Subject: FW: BE/89/19/PL

'The change of use of land for the storage of building materials, equipment & plant & for the parking for fixed body vehicles

together with part boundary screen fence with a secure gated access point to the site.'

PROPOSED SITE PLAN - 1:200

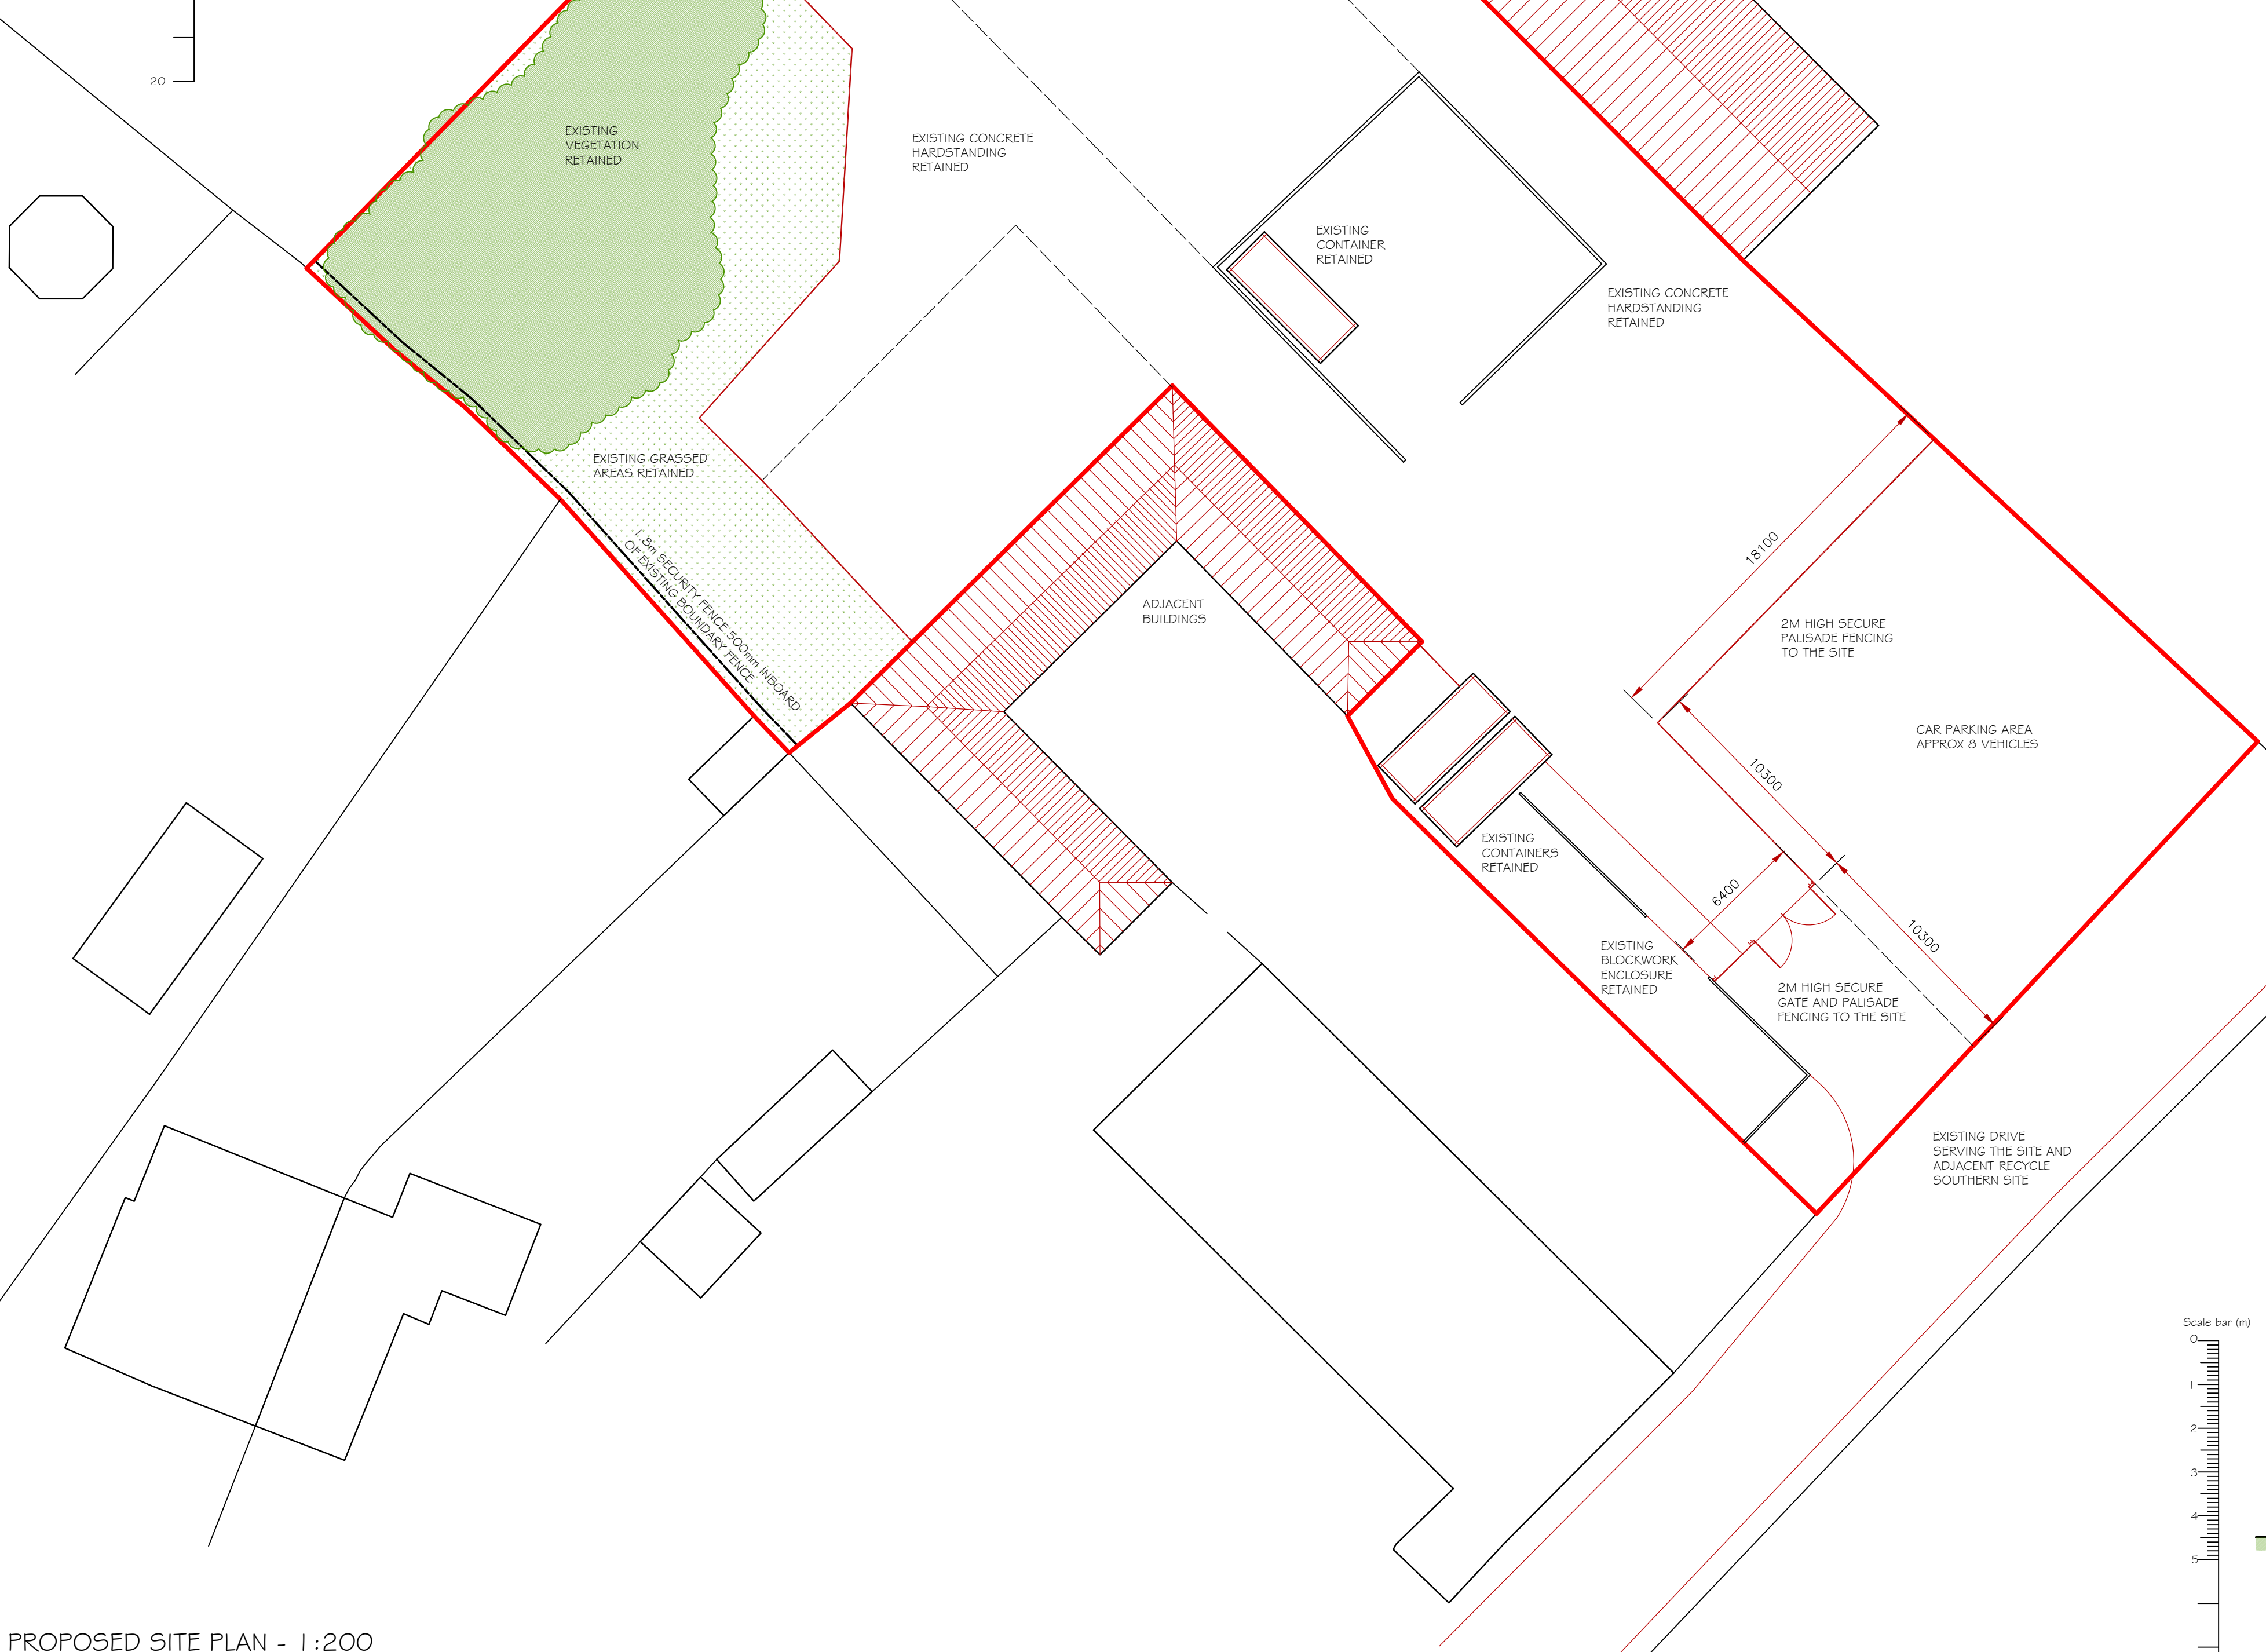
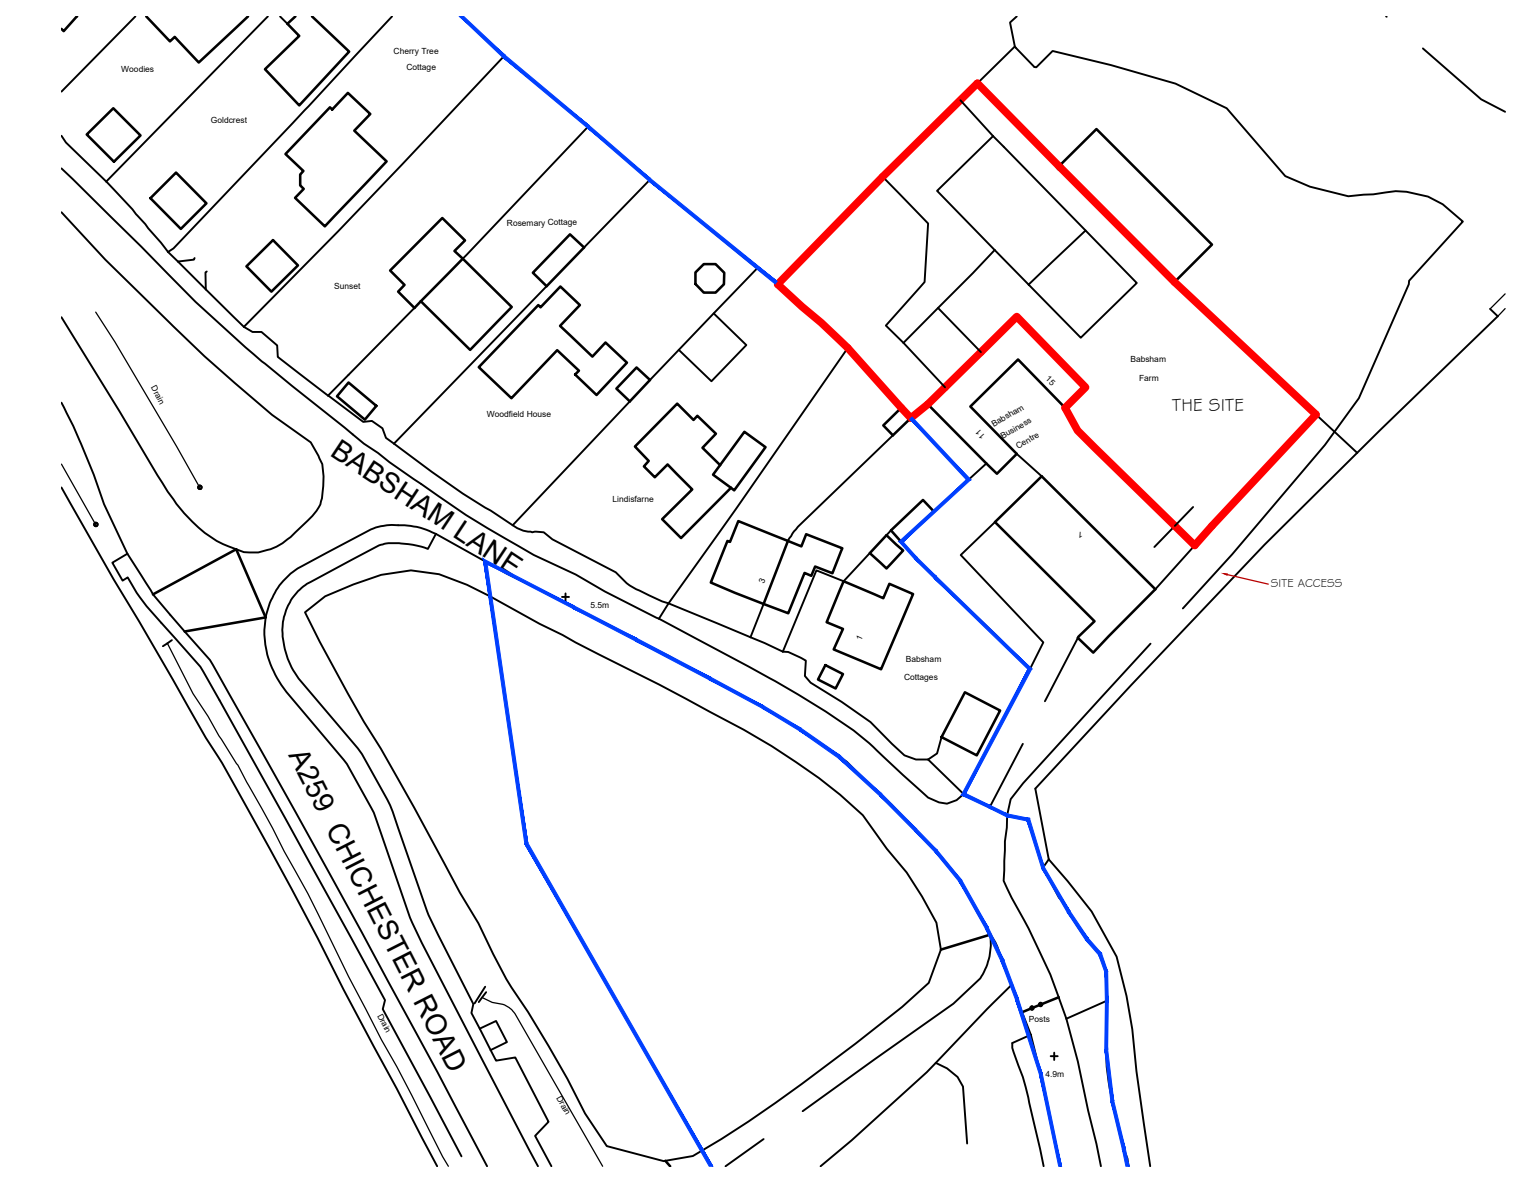
I have just sent my response to the planning inbox, I have requested more information, as although they has demonstrated the gate, they have revised the plan to show 'parking for up to 8 vehicles', no longer designated HGV parking for 2 HGVs as the application suggests – are they now proposing parking for 8 HGVs? They also have not shown how HGV vehicles will turn on site – particularly, if there are 8 proposed HGVs, there will be limited space. If they are now proposing the parking area for cars only, where are they now proposing HGV parking? And could any revised HGV parking area provide suitable turning provision?

in this position immediately behind gardens wall only the same height as this wall (for the sake of view, the picture attached to my previous email). From a practical (unpractical) point of view the gap of 15 cm is non sense. At least 50cm would be reasonable.

I have discussed the fence with Dan and I have been invited by the local resident to see the site from her point of view and I have attached photo. The proposed fence is much better, however not immediately behind of the rear of residential gardens.

And what about the space in the between? How much and how it will be kept?

'The applicant has referenced that gates will be erected on the access track to improve security. No details of the proposed gates have been provided. The applicant is requested to demonstrate the location of the proposed gates on the plan, including details of how and when these will be in operation, and any necessary measures that will be taken to avoid vehicle conflict and queuing on the public highway.

The applicant has not demonstrated how articulated vehicles are currently turning on site. The applicant is requested to provide details of this, and if necessary, should demonstrate with swept path analysis that the proposed positioning of the gates will not impact upon the ability for articulated vehicles to turn on site.

What we request is the position of the proposed fence to be changed (as suggested).

Please find attached a revised site plan indicating the proposed secure fencing adjacent to the existing boundary fence.

I have indicated the fence line 500mm offset from the existing as suggested.

We intend on indicating a palisade type fence across part of the frontage of the site with a defined parking area outside of this fence line. The parking area will be for fixed body vehicles (cars, vans and on articulated lorries etc.) belonging to the tenants of the site only and will be subject to the operating hours of the site only - to be agreed under condition.

Within the palisade fence there will be a secure gated access point to the site.

With regards to the proposed fence at the rear of the site our client is proposing removing the fence completely from the application and will rely on the existing rear garden fences of the adjacent properties and the part masonry walls already on site. The area of existing planting and self seeded trees and shrubs will be retained.
